Design Advice

Application Number	15/01012/OUT
Applicant's Name	Albion Land Ltd
Application Type	Outline
Location	BICESTER 11 - SKIMMINGDISH LANE, BICESTER
Case Officer	Andrew Lewis

Outline – Development of 48,308sqm of employment floorspace

**Figure 5:** Development Area and Building Zone Parameters Plan

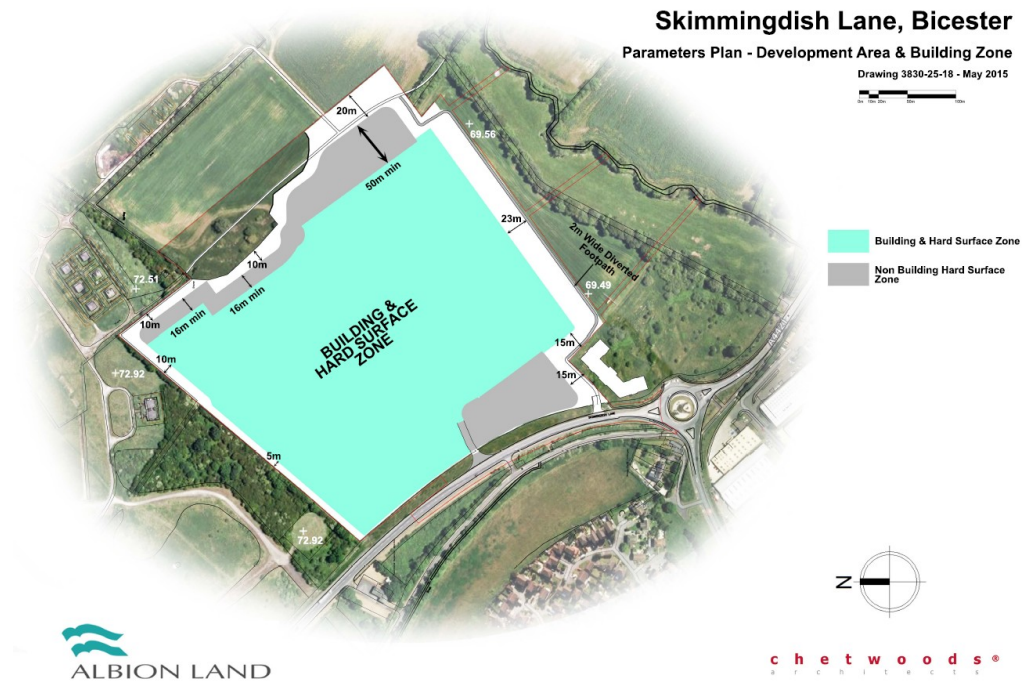
The LPA supports the principle of commercial development at Bicester 11; however we have a fundamental concern regarding the scale and height of the development proposals. In assessing the impact of the development proposals set out in the application, we have to consider the maximum scale of development that the parameter plans would support. The parameter plans indicate that up to 48,308 sq m of development is proposed. This figure can be translated into a building envelope of 240m length, 200m wide and 16m high (14.5m at the eaves on some frontages).

**Figure 6:** Site Levels and Building height Parameters Plan

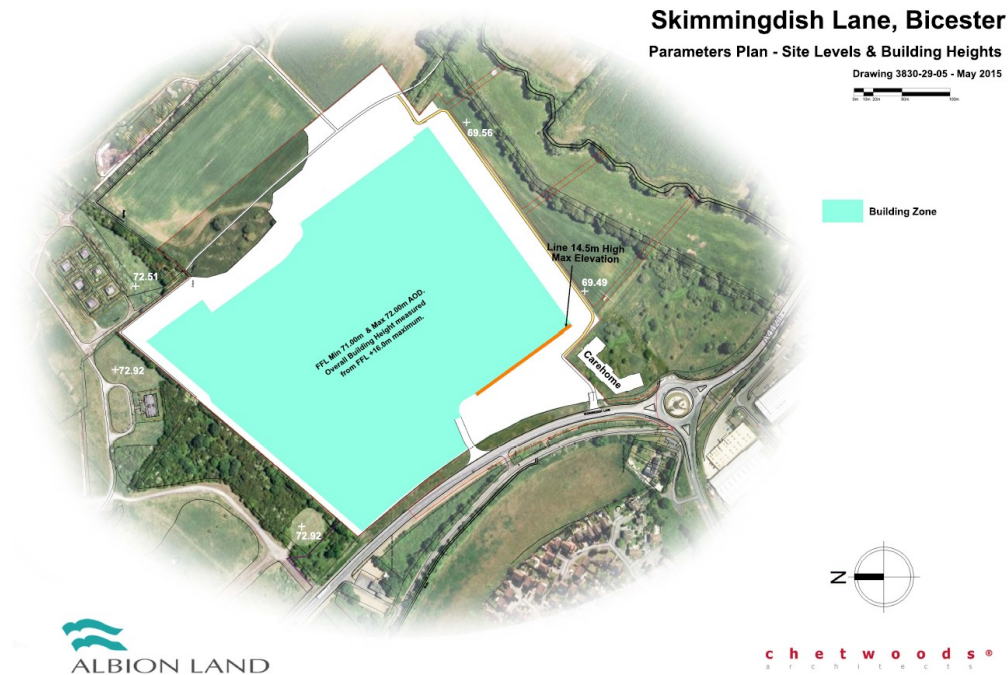
The LPA has been consistent in their advice to the applicants that the height of the proposals is a fundamental concern which makes them unacceptable. The applicant has stated on a number of occasions that they cannot negotiate on the height of the building as 16m is an operational requirement. There are economically viable warehouse and distributions buildings of all shapes and sizes up and down the country and given the sensitivity of the site and its adjacent heritage constraints it is considered reasonable that the scale of the buildings is reduced to mitigate the impact.

The LPA has considered how the height parameters could be amended to reduce the building to an acceptable scale. Based on the views from the Watch Tower at RAF Bicester, we would recommend that the height is reduced to meet the following parameters (see figures 1, 2 and 3):

- The height of development should not break horizon line of near trees (as annotated in the attached figure)
- As a guide as to the appropriate height, the top of the Grade 1 listed tower at St Mary's Launton should not be exceeded.
- The reduction in height could be achieved through a combination of reducing the overall building height and finished floor level.
- In addition, the following issues should be considered at Reserved Matters, to further reduce the impact of development:
 - Breaking down the massing of the built form
 - Materials / finishes that reduce impact by blending with landscape
 - Green roofs
 - Landscape structure planting
